BROOKFIELD MULTIPLEX

SCIENCE AND ENGINEERING BUILDING
UNSW

ACCESS REVIEW

5th July 2016

DRAWING LOWER GROUND FLOOR ZONE A
DRAWN DL CHECKED CF AUTHORISED MJ
DRAWING NUMBER A03 1001 A-SSD REVISION 1

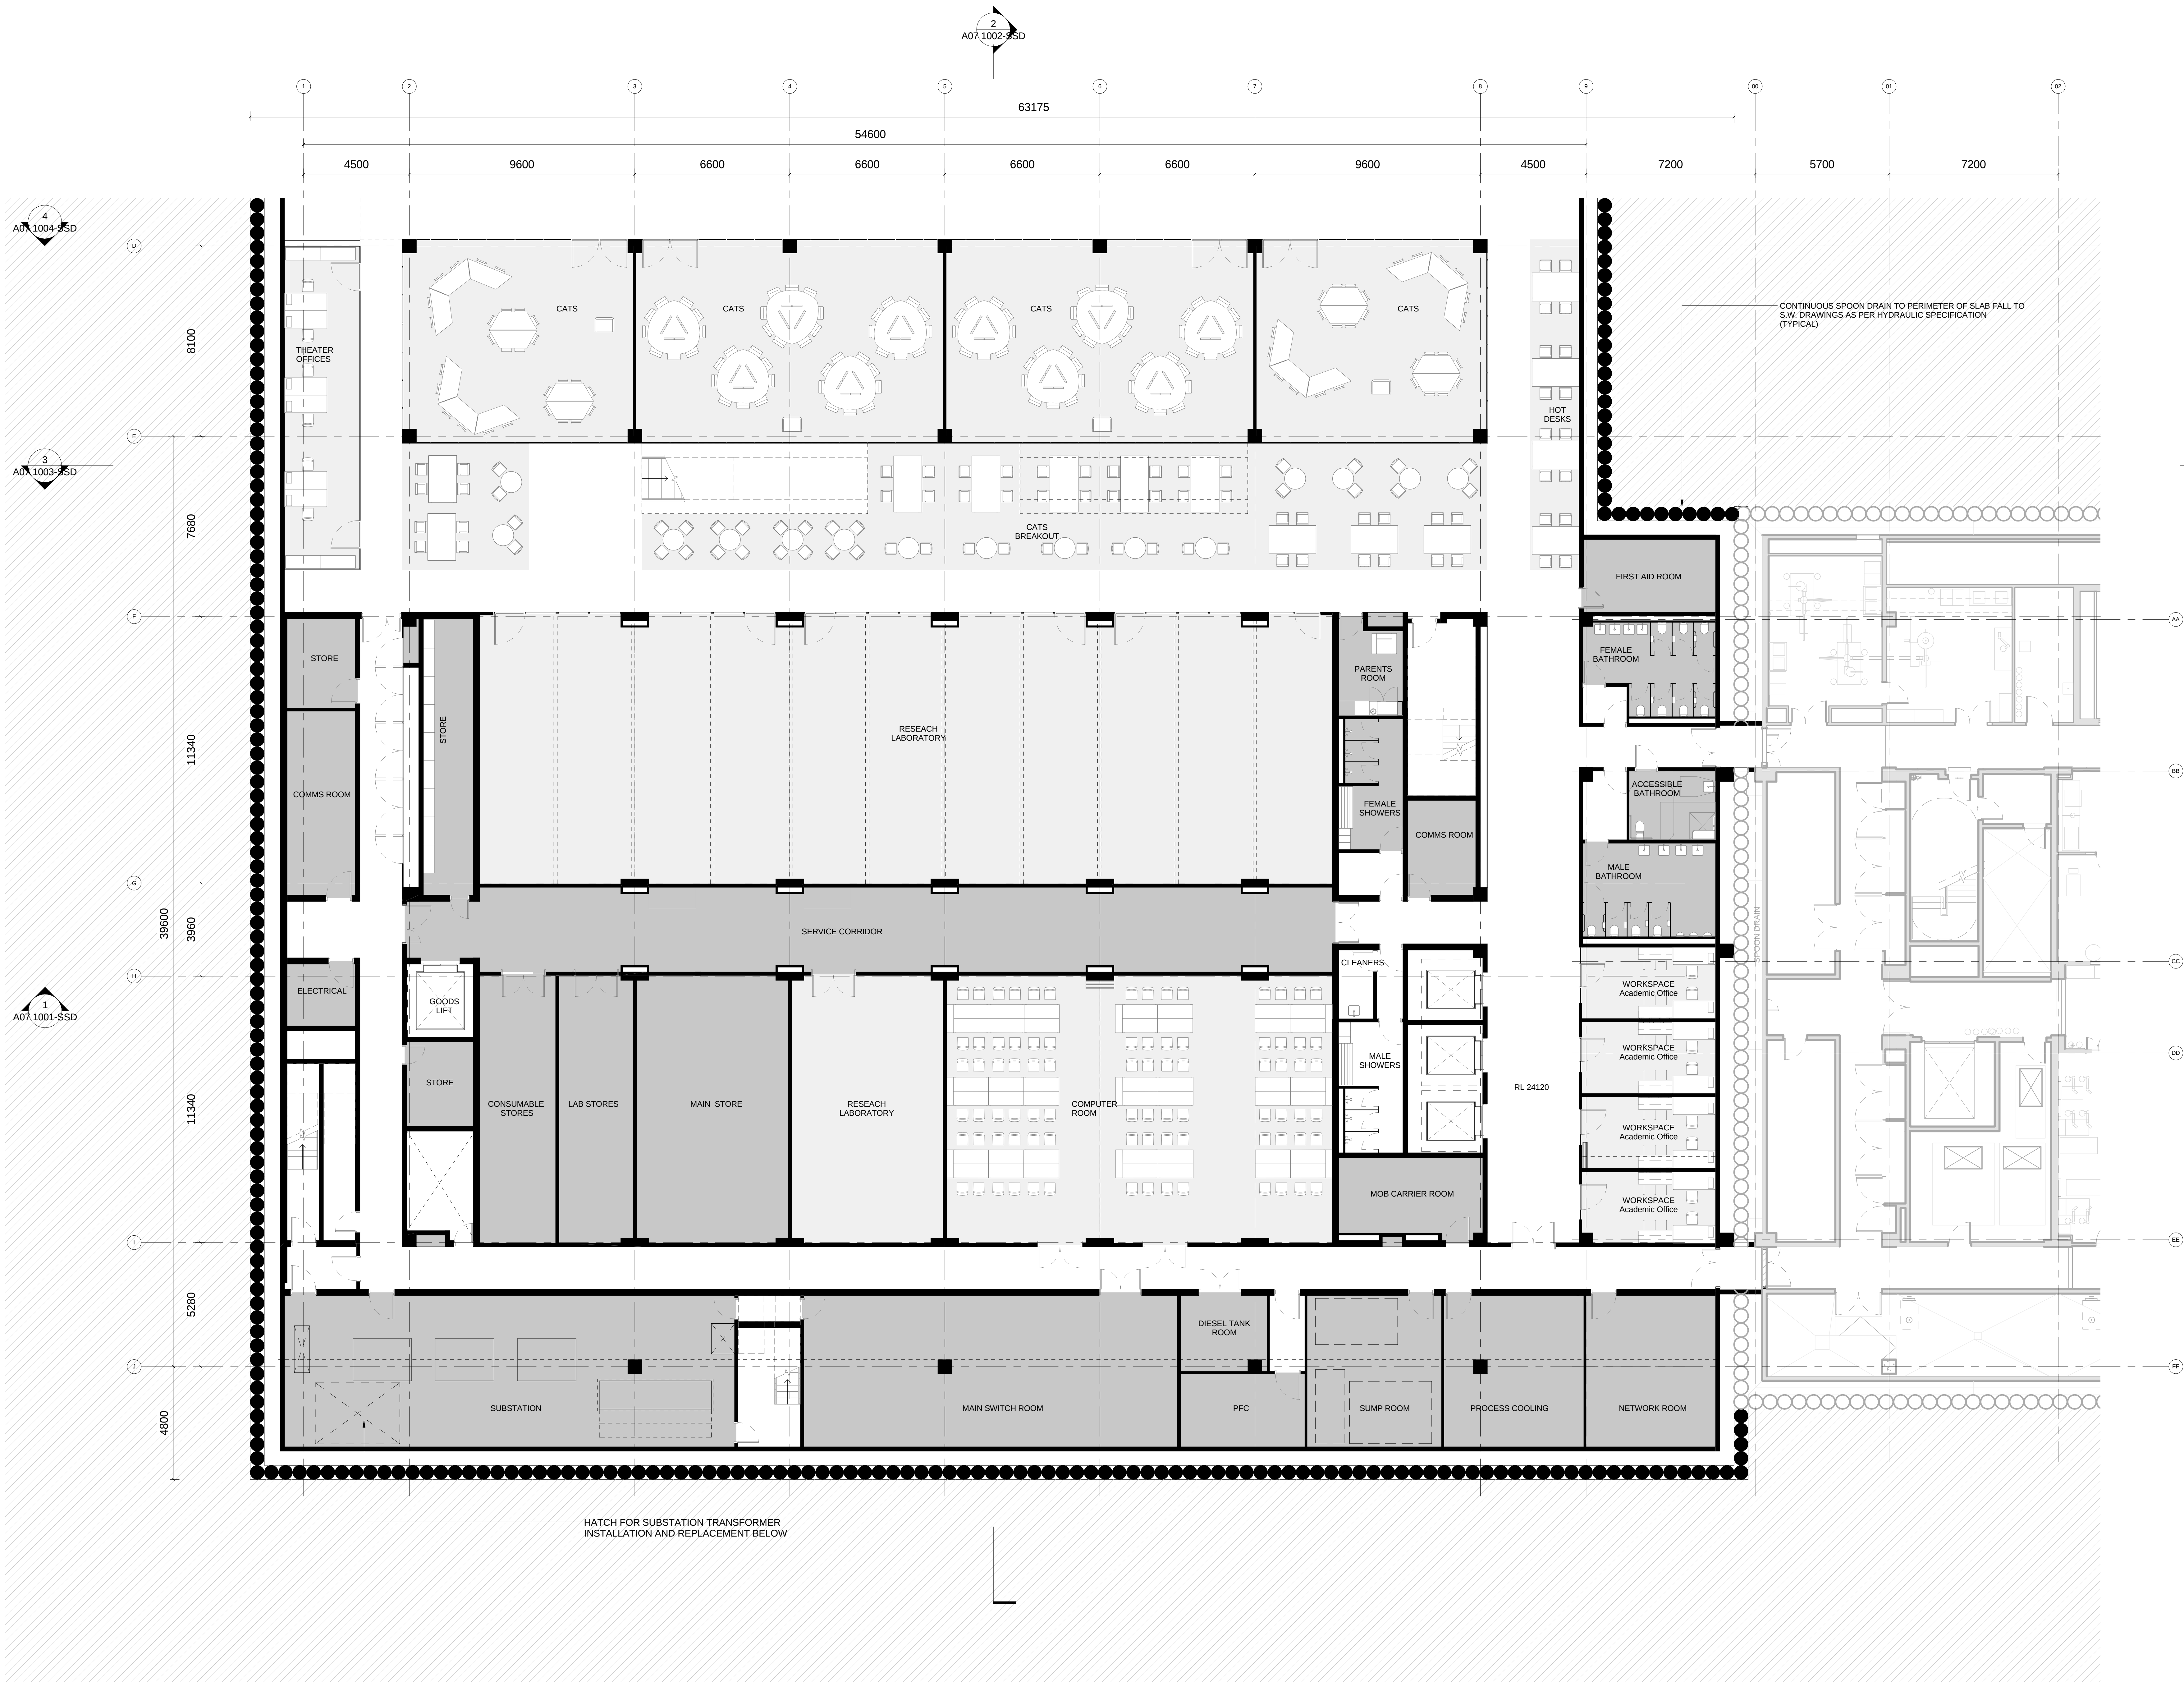
The IO Meyer Theatre is located on the Lower Ground floor. The theatre is a flexible space with no fixed seating and no elevated stage area. The facility consists of store rooms, workshop, studio spaces and breakout areas.

Associated with the theatre there is a bank of male and female dressing rooms including showers and ambulant cubicles. There is currently no accessible dressing room/shower for performers with disability. Review is required to provide an accessible shower and sanitary facility in accordance with BCA 2016 Table F2.4 (b)

- (i) Provide an accessible dressing room sanitary facility with shower adjacent to the male and female dressing rooms of the IO Meyers Theatre, in accordance with BCA 2016.

DRAWING
GROUND FLOOR ZONE A

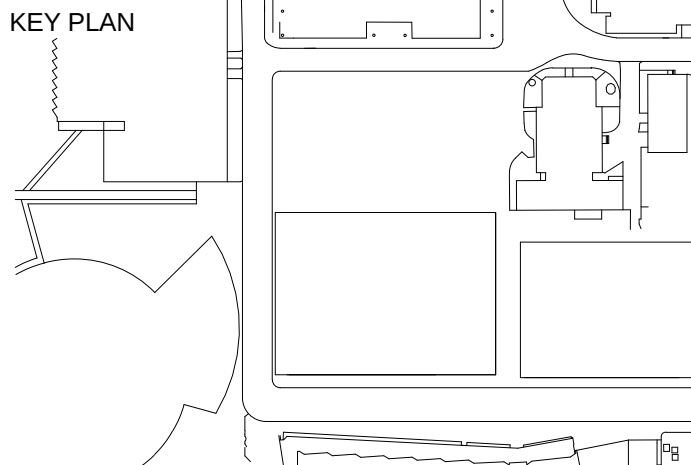
There are several pedestrian entrances to the proposed building. The primary pedestrian entrance is located off Union Road between the proposed new building and the existing Material Science and Engineering Building. It is unknown if there is a level difference between Union Road and the pedestrian footpaths, review is required to provide a step free path of travel from Union Road to the pedestrian footpaths of Union Road. There is a series of walkways leading to the main entrance doorway and podium level, which is approximately 1M higher than the pedestrian footpath level. Either side of the walkway are a set of stairs, review is required to ensure the stairs are compliant with AS1428.1:2009.

The Primary Entrance (northern and southern elevations) is located between the proposed Science and Engineering Building and the existing Material Science and Engineering Building. The main entry doors appear to be automatic sliding doors achieving clear opening widths and circulation spaces inside and outside of the doors. A path of travel is achieved from the Primary Entrance to the lifts. Outside the lift on each floor there is sufficient area to enable a wheelchair passing space (1800 x 2000mm), compliant with AS1428.1:2009.

Generally where communication stairs are located adjacent to corridors and walkways, the stairs are to be set back to allow for handrail extensions without protruding into the transverse path of travel. The handrail extensions around the main stair (between each building) will currently protrude into the adjacent door circulation.

- (i) Ensure a kerb ramp is provided from Union Road to the pedestrian footpaths of Union Road adjacent to the primary entrance, to provide a step free path of travel, in accordance with AS1428.1:2009.
- (ii) Ensure any walkway/ramps have maximum gradient of 1:20 with landings at intervals of 15M (walkway), or maximum gradient of 1:14 with landings at 9M (ramp) intervals, compliant with AS1428.1. Ramps are required to have handrails to both sides of the ramp, handrail extensions and TGSI's.
- (iii) Stairs located adjacent to footpaths are to be set back from the pedestrian footpath (boundary) a minimum of 900mm to allow for handrail extensions and TGSI's, compliant with AS1428.1:2009.

- (i) Handrails to communication stairs are to be of a continuous height, provided to both sides of the stair and to have handrail extensions top and bottom of stairs, compliant with AS1428.1:2009.
- (ii) Ensure stairways are suitably recessed from transverse paths of travel so that required handrails extensions do not protrude into corridor spaces, door circulation areas etc., compliant with AS1428.1:2009, fig 17.
